Applicant: Mathew Flaherty

Address: 73(75) Haworth's Way (lot 3)

permit # 2015-00336

CHECK-LIST AGAINST ZONING ORDINANCE

MAINE RESIDENTIAL DESIGN	FILE NAME
CASCO, ME. 207-627-3362	A1 OF 9
JOB: MATT FLAHERTY VER 2	SCALE: 1/4"=1'-0"
DISCIPLINE: PRELIMINARY	DATE: 2/18/2015
	DRAWN BY: MEJ
	APPROVED:

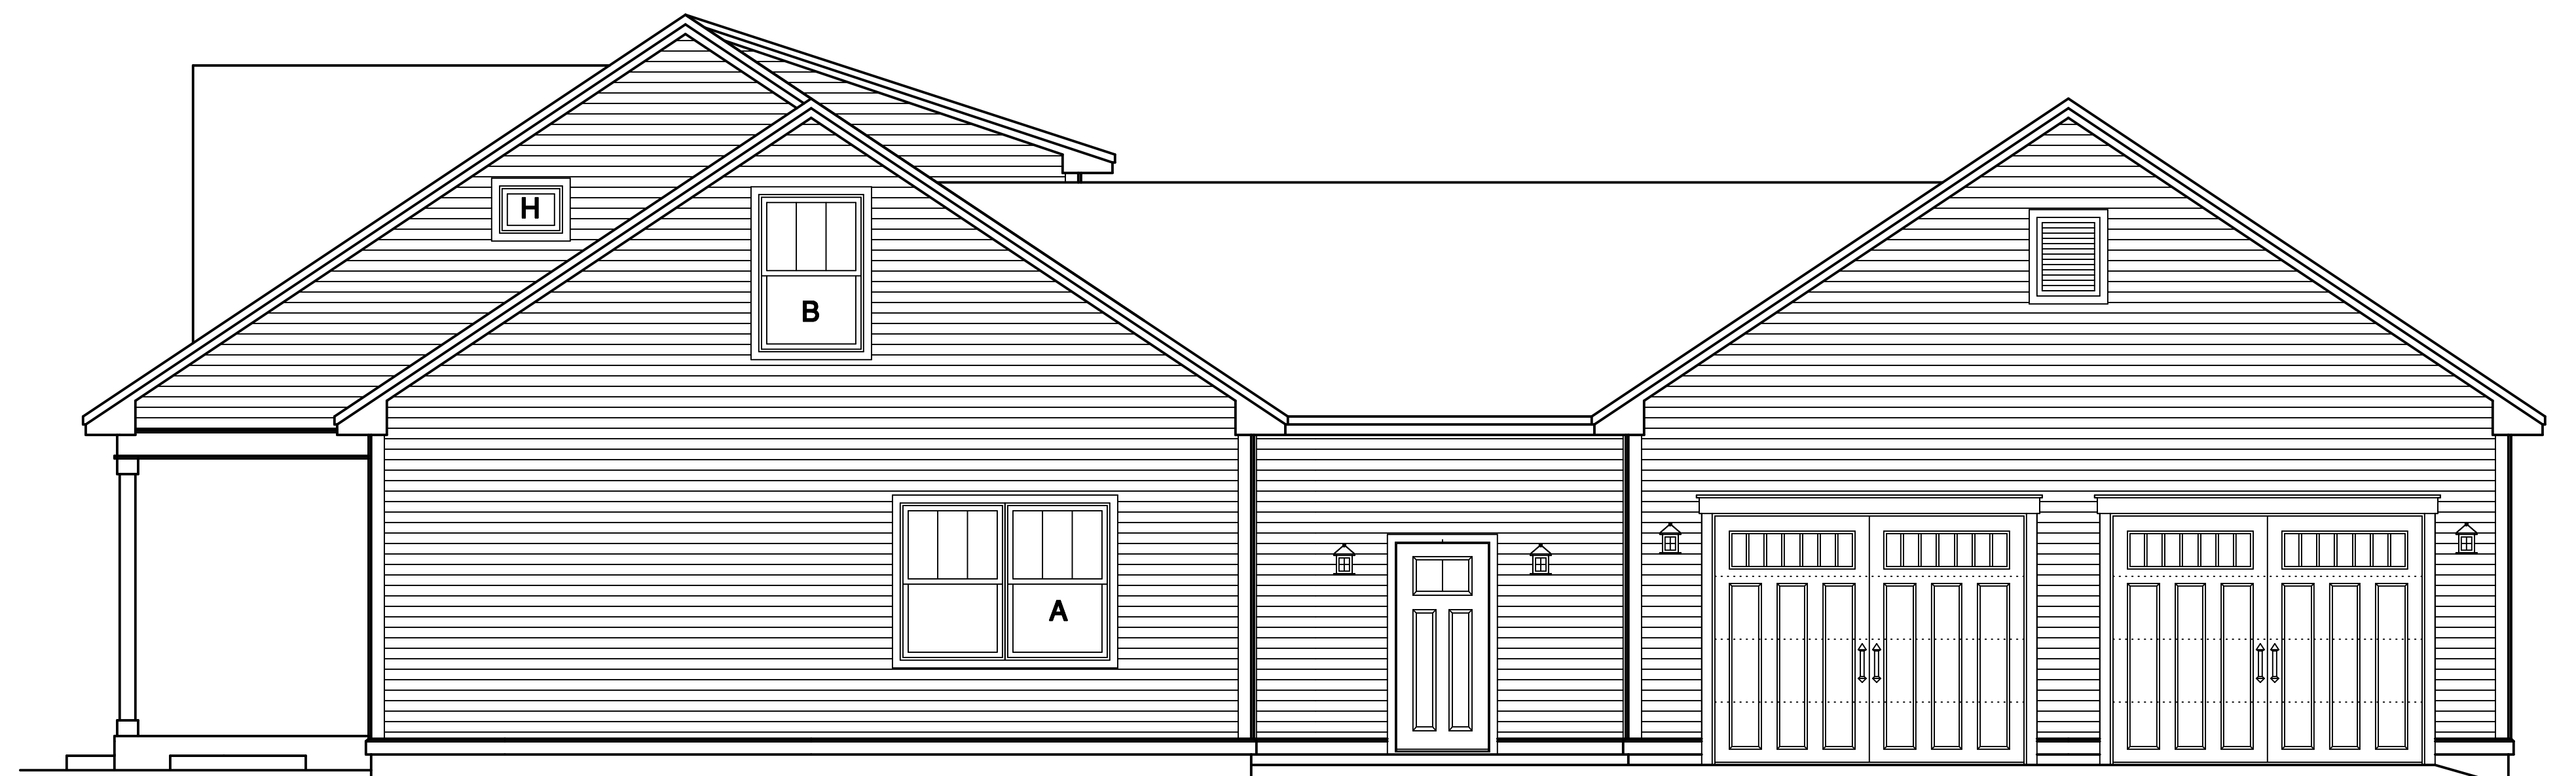
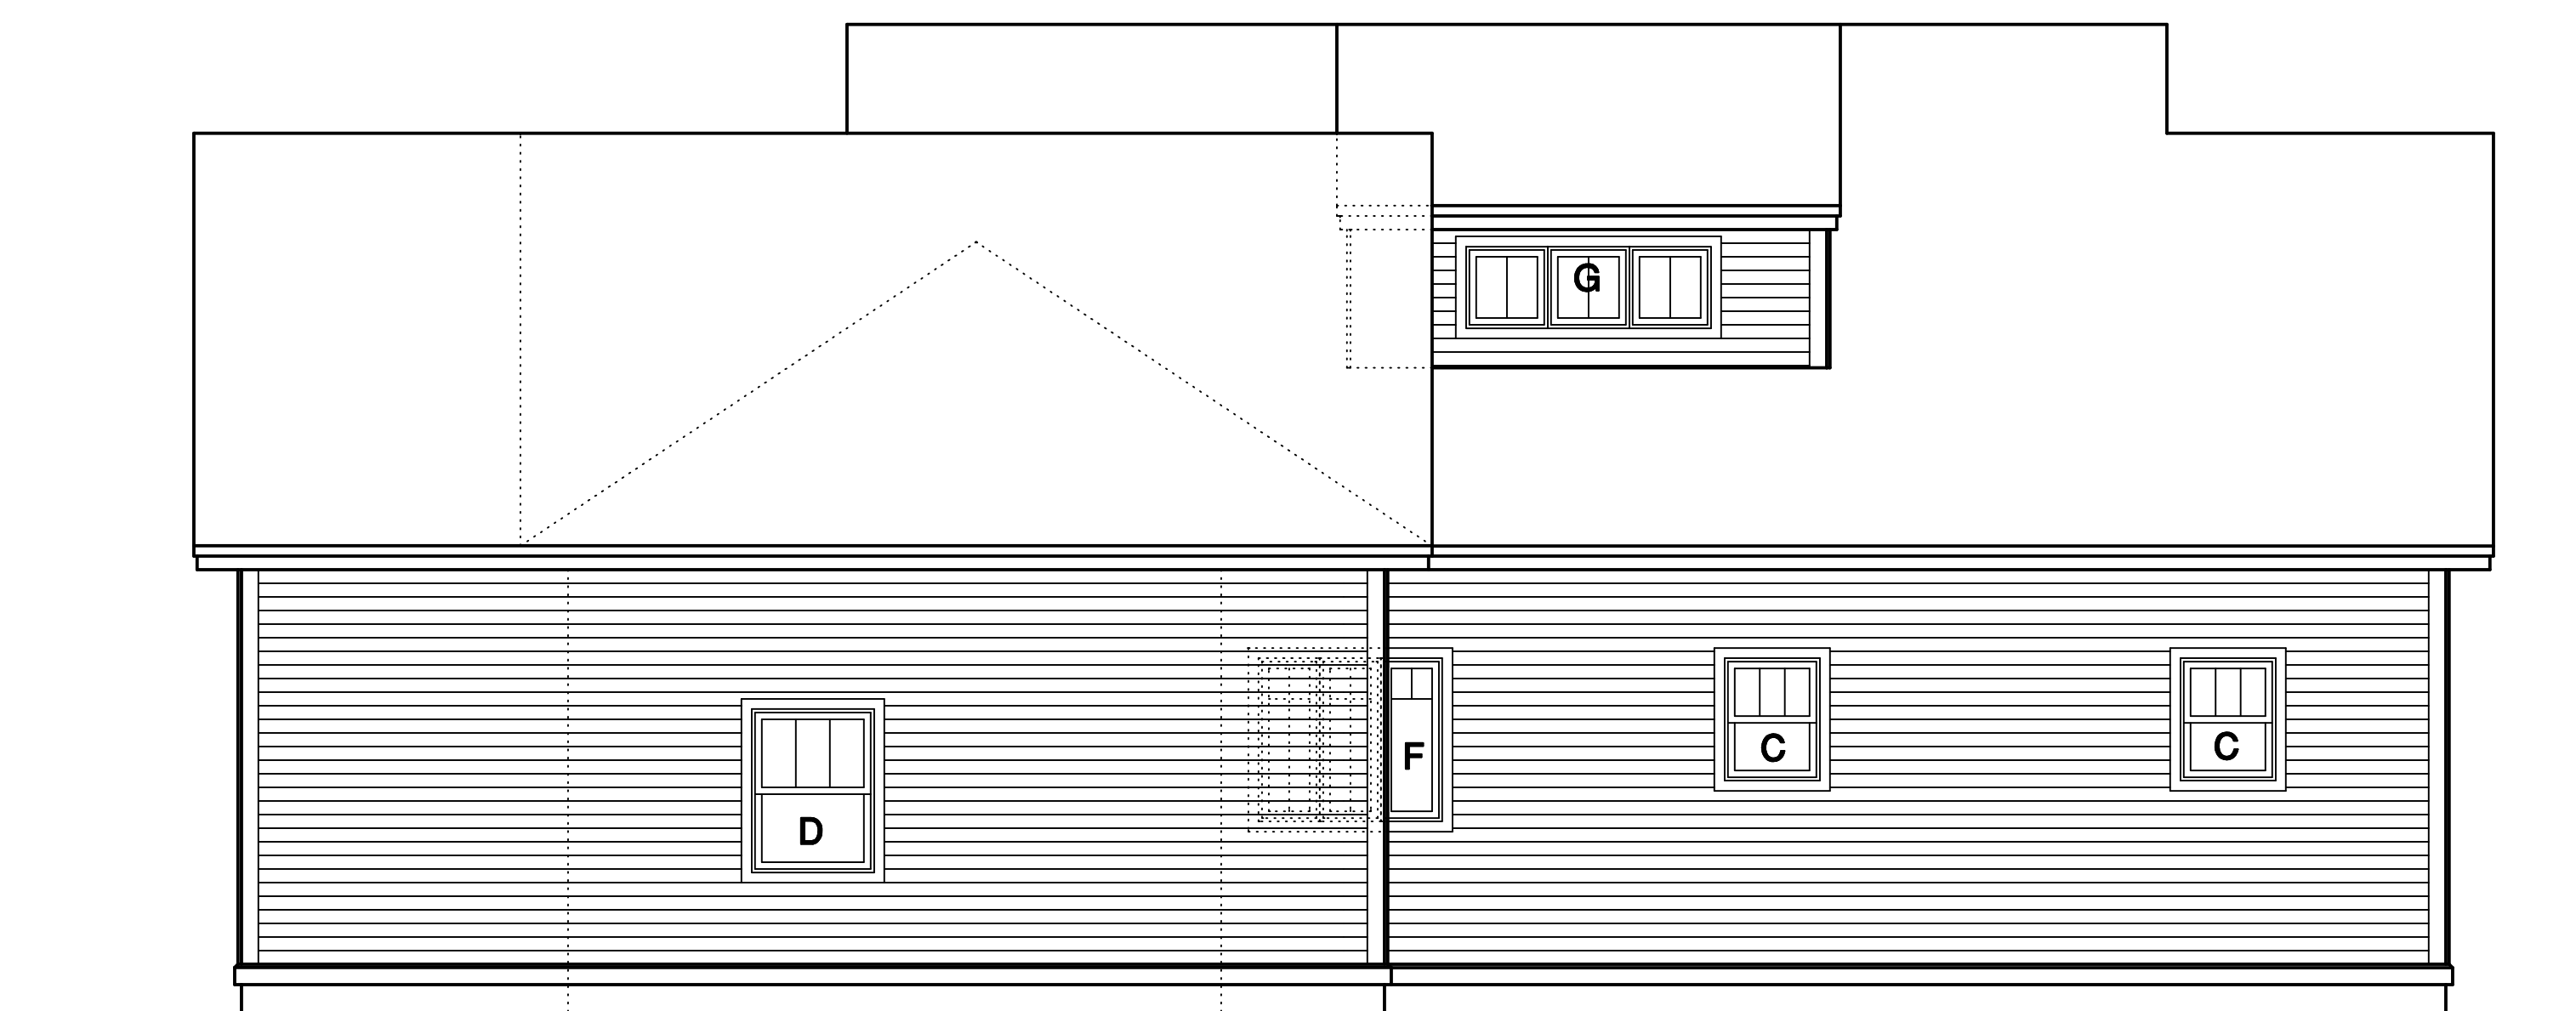
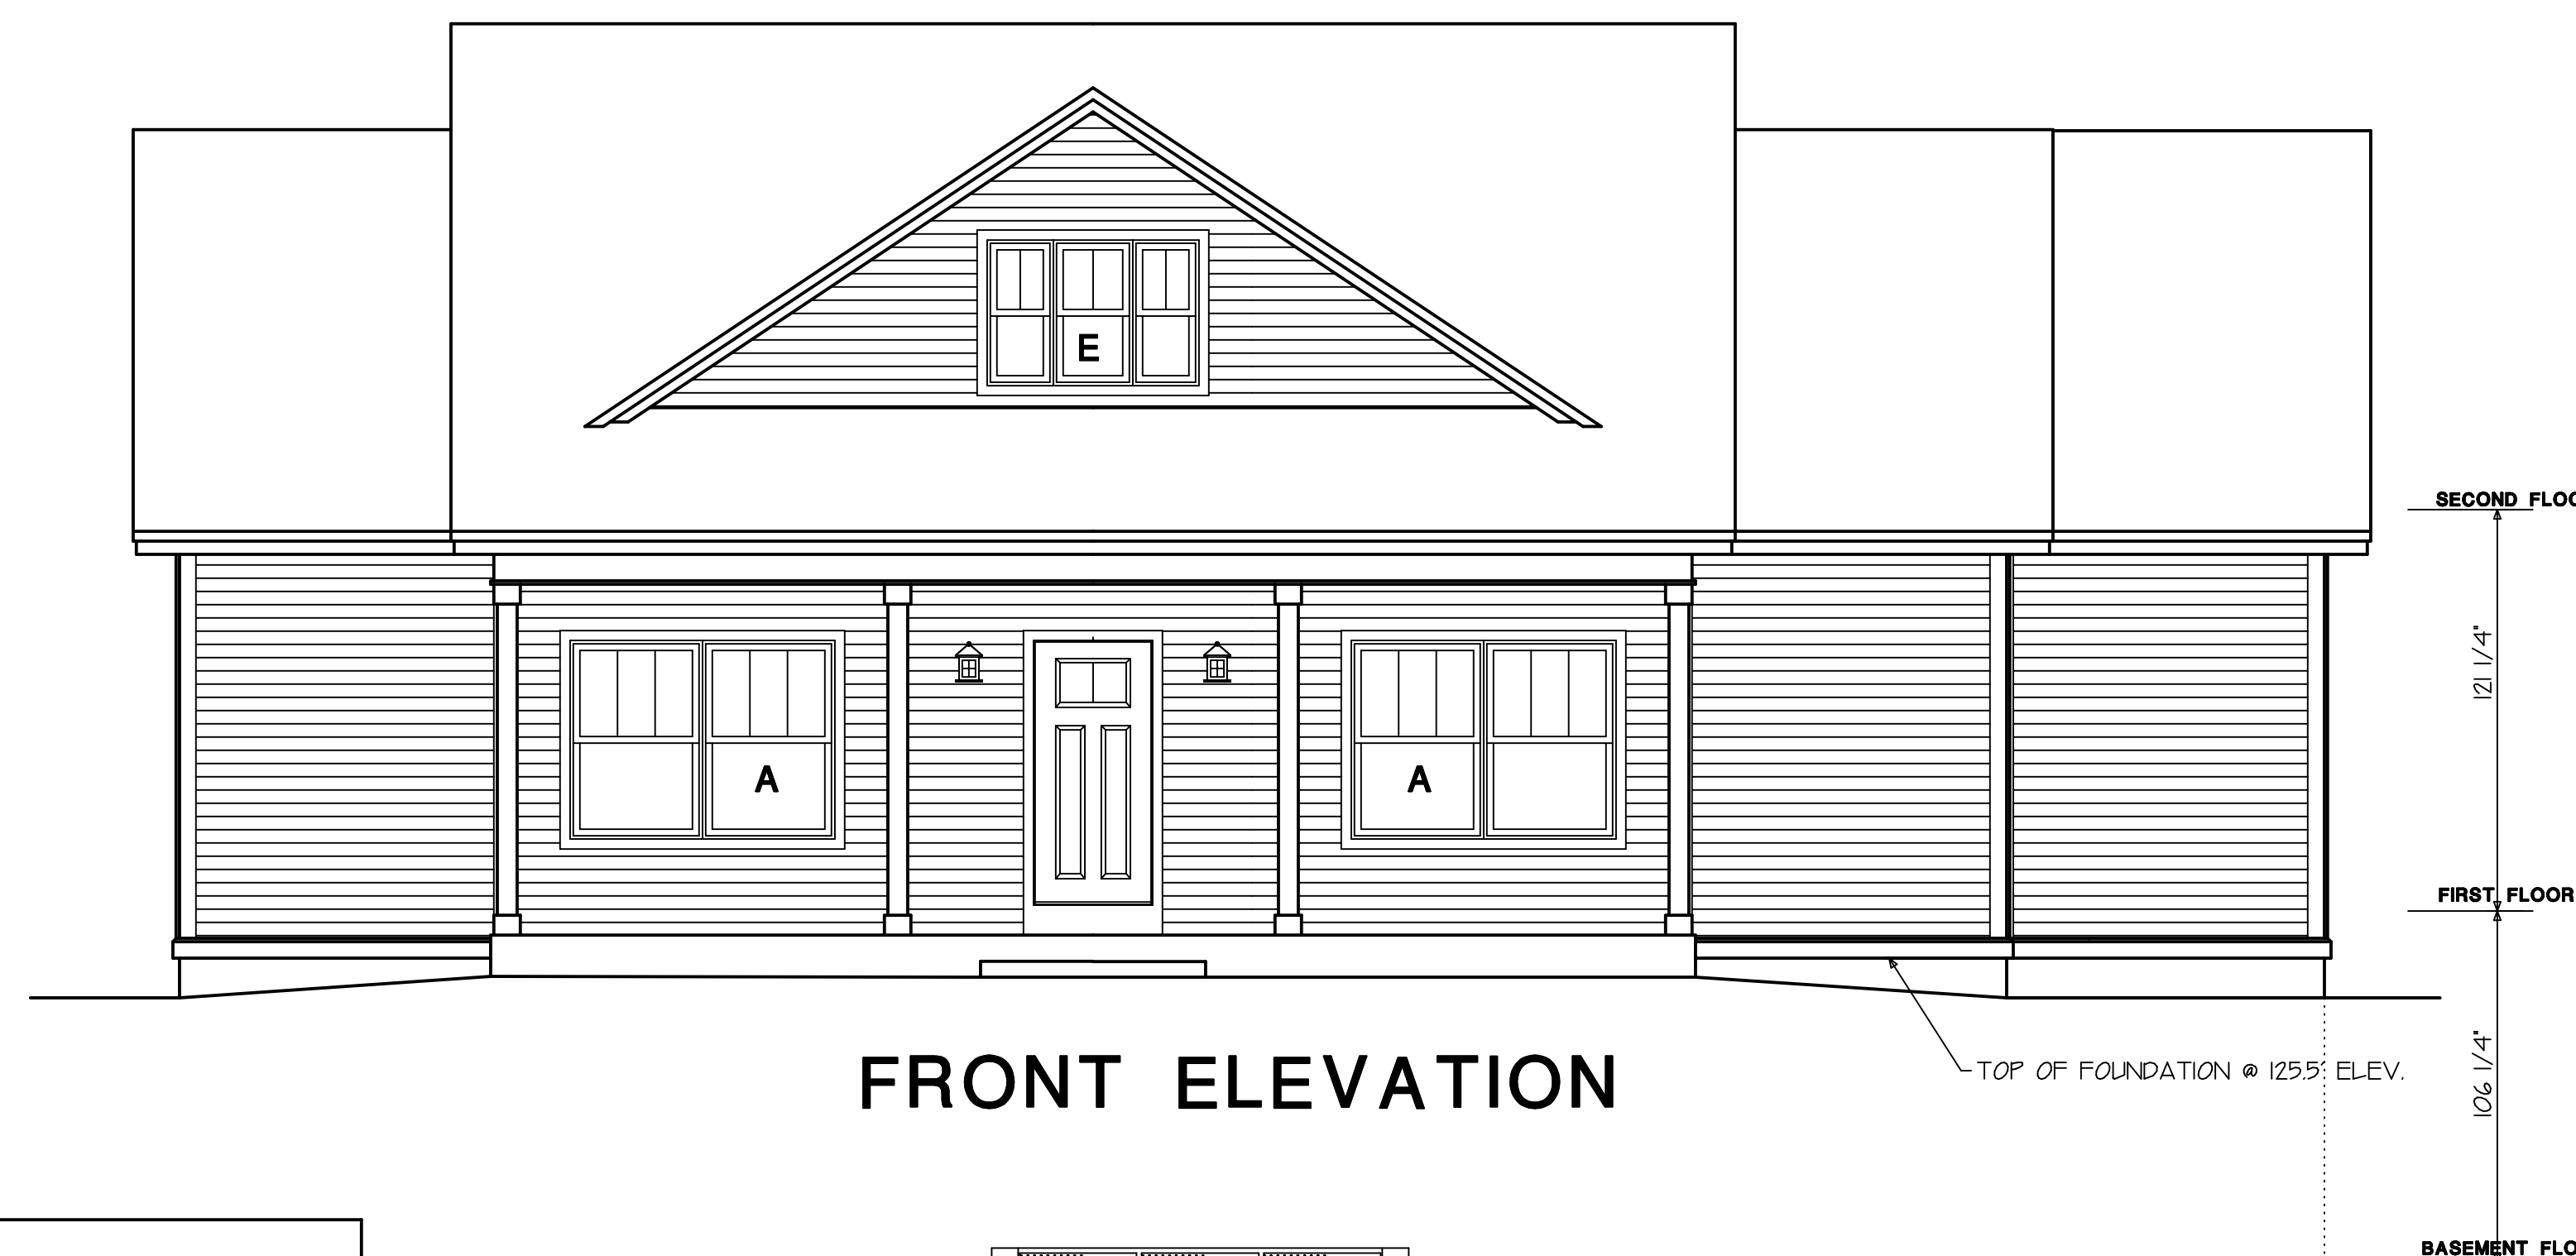
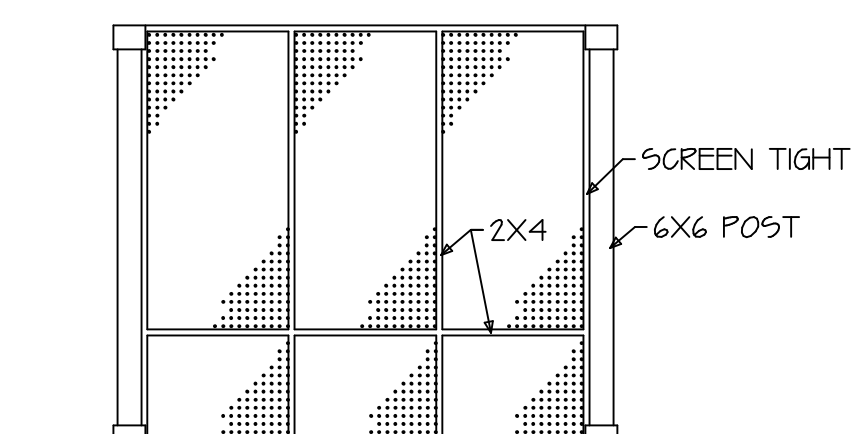
Height - 35' max - 24.19' to highest point - OK
